Barnsley West Planning Applications

2021/1089 Employment Hybrid Application and 2021/1090 Residential Hybrid Application

Summary of officer comments on the Interim informal submission of revised details and LVIA details, dated 27 July 2023.

# VIEWPOINT H

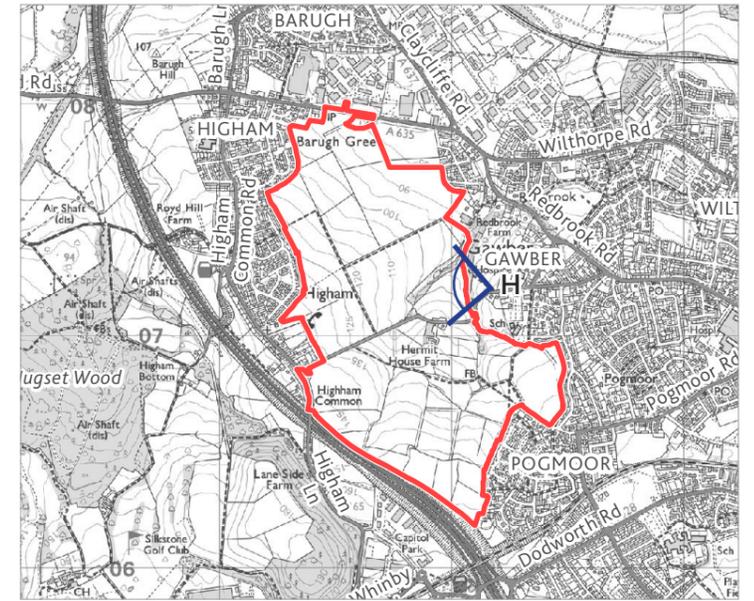
travel - confirmed in the Masterplan, Design and Access Statement and the Landscape Strategy
Turning facility required for Hermit Lane	The Masterplan confirms a proposed turning head at the point where Hermit Lane currently enters the MU1 site on its eastern boundary.
